Householder Proforma

Application Ref: 2021/0788

Address: 14 Highfields, Hoylandswaine, Barnsley, S36 7JP

Proposed: Alterations to dwelling including raising of roof, addition of dormers, balcony and rendering of property

TITLE:
Proposed 3D Views

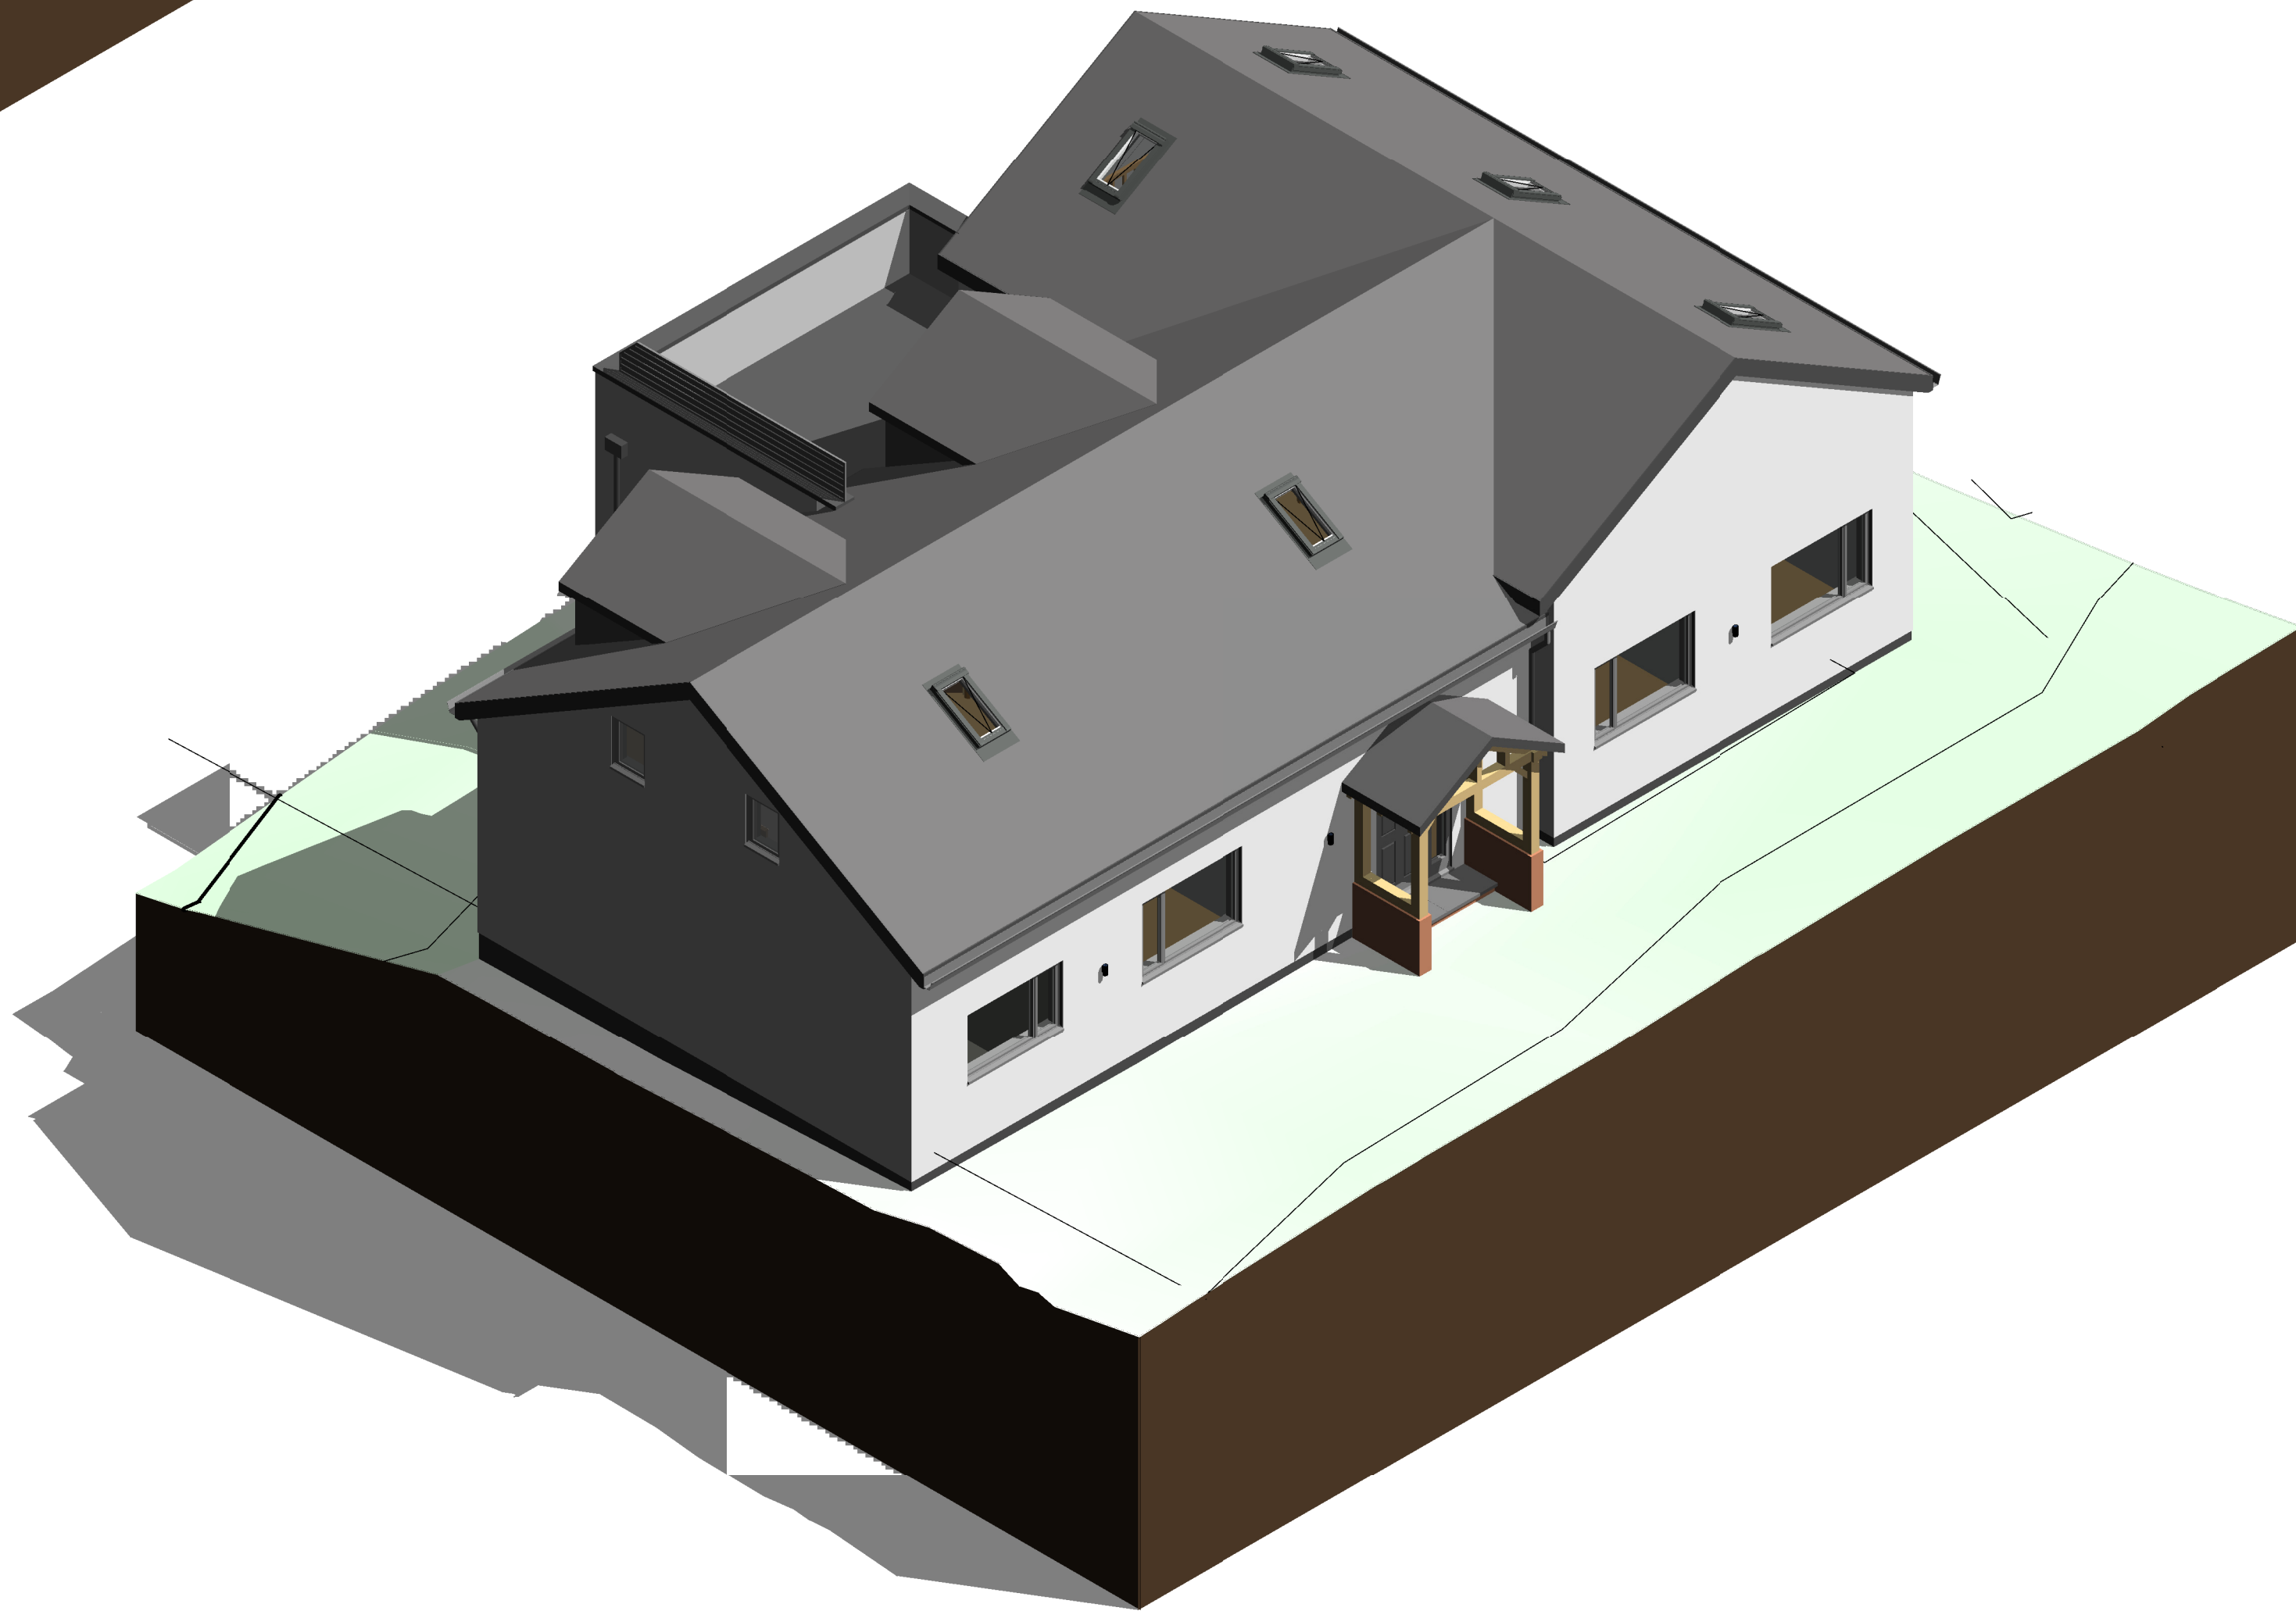
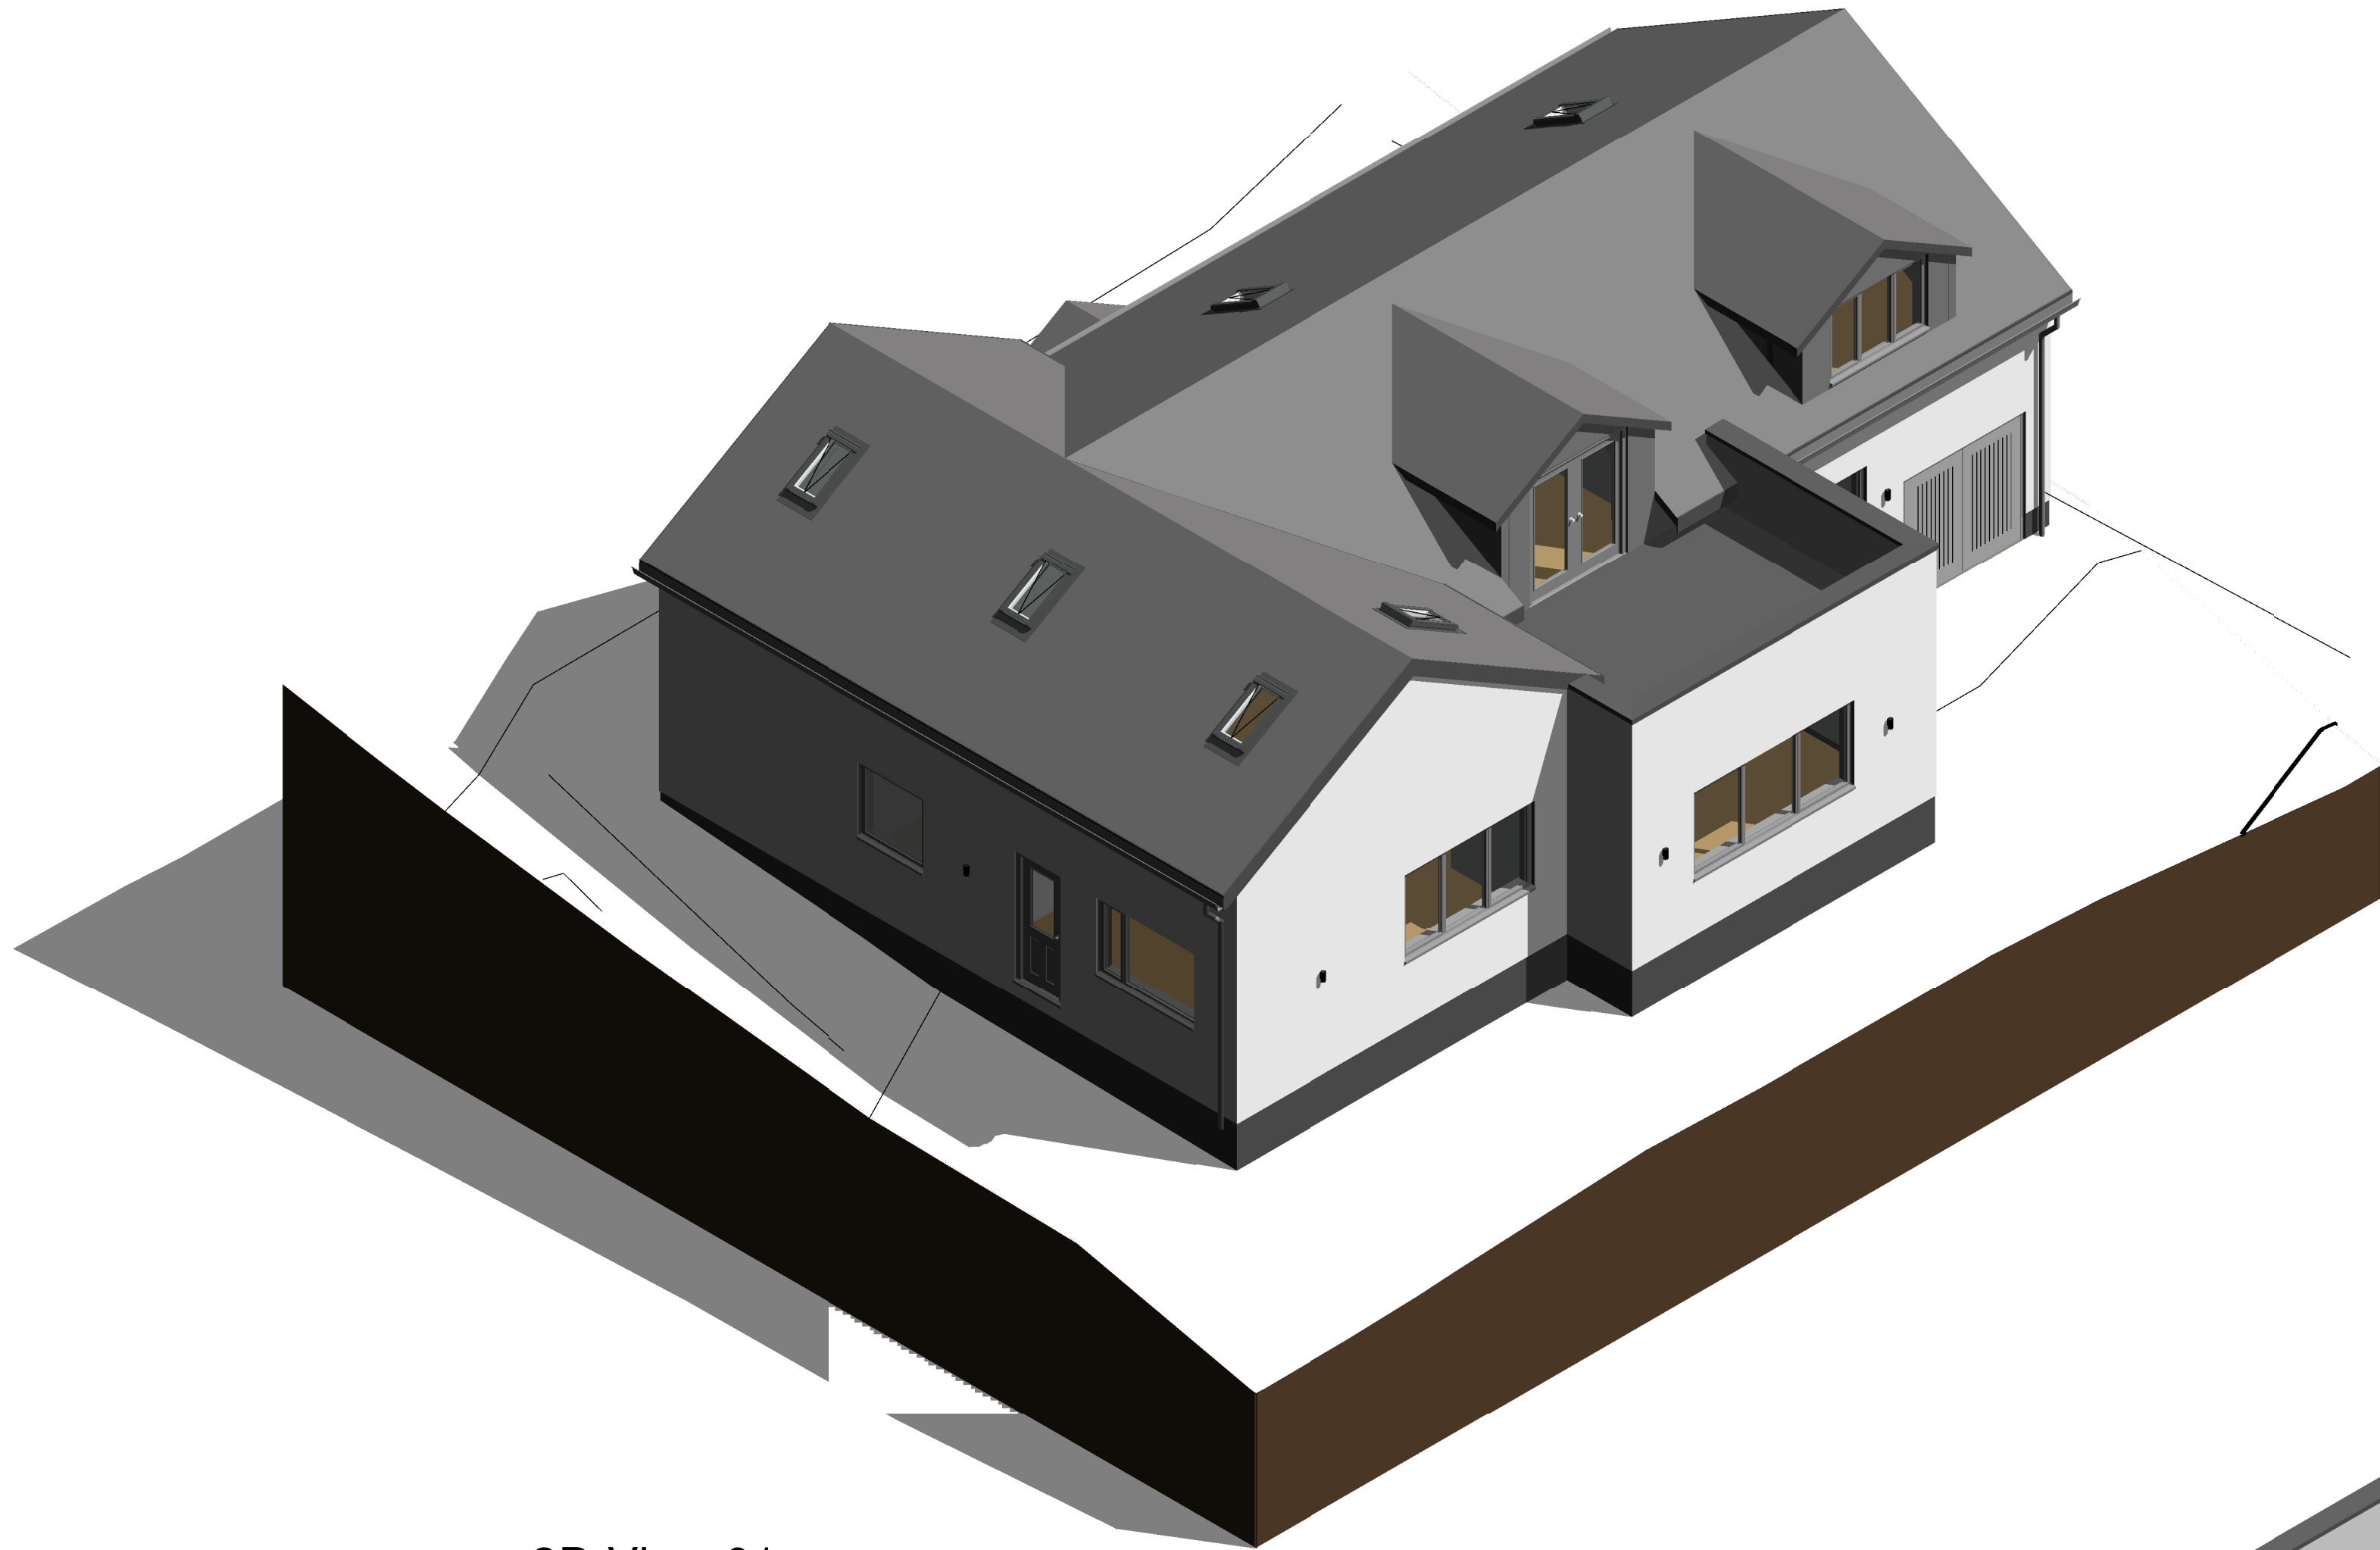
Single Storey	
1. terraced property and less than 3.5m (projection to rear)?	
2. semi-detached and less than 4m?	Existing rear extension – balcony proposed to this structure.
3. if more than 3m are the eaves more than 2.5m in height?	
Two Storey	
4. terraced property and less than 2.5m (projection to the rear)?	
5. semi-detached and less than 3.5m?	
All	
6. materials to match	The whole property will be rendered
7. roof design compliments / ties in well	Proposal for 1m wall to sides of existing extension to create balcony. Screening to west elevation which will protect amenity value of No. 16 garden area. The screening is proposed grey finish timber/composite
